## Application for a Non-Material Amendment Following a Grant of Planning Permission

23/00887/HOUSE

Addition of a skylight (velux) that has been missed on the plans initially and addition of the chimney flue according to Building Regulations.

DRAWING NO: PL 007B

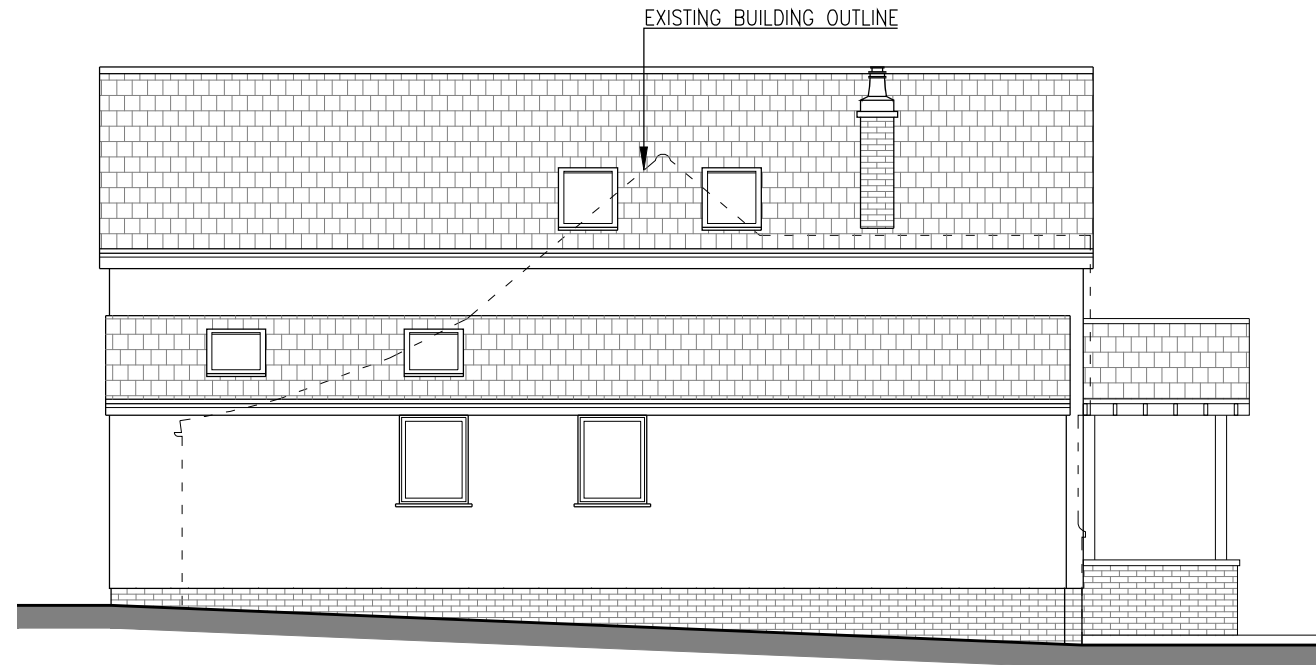
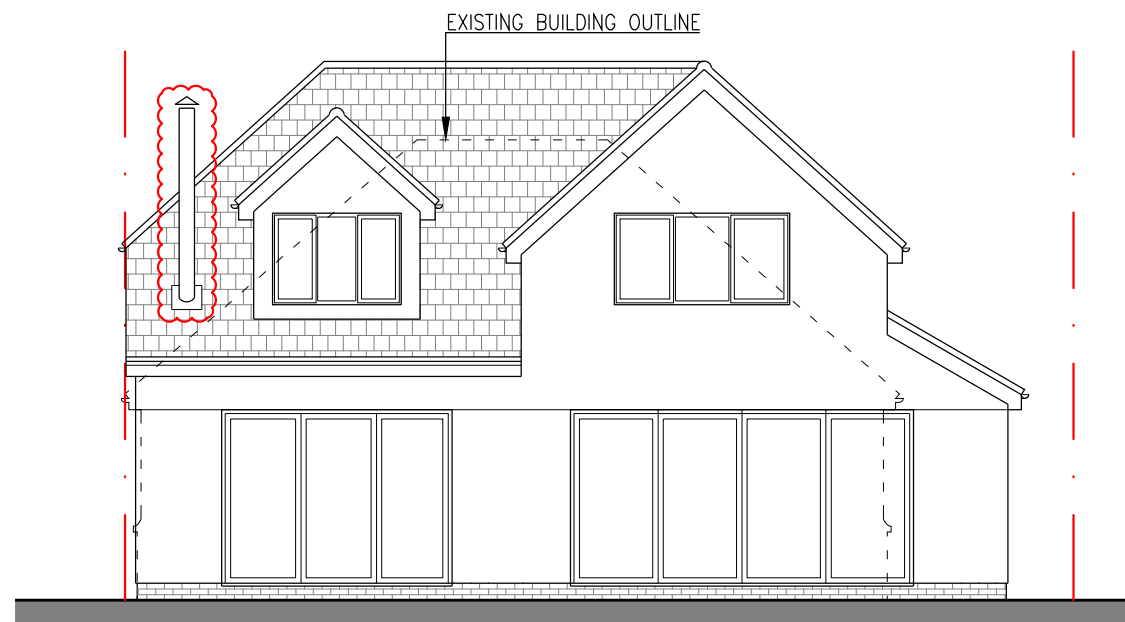
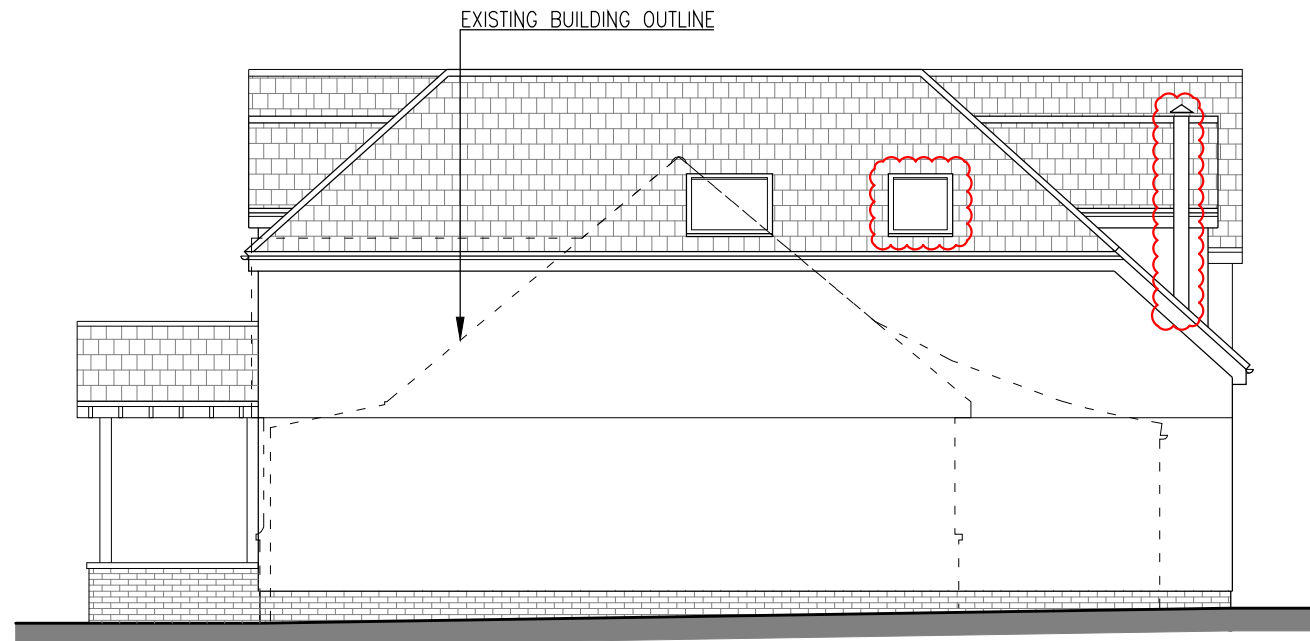
That side of the house has a smaller dormer window and must benefit from increased daylight as much as possible.
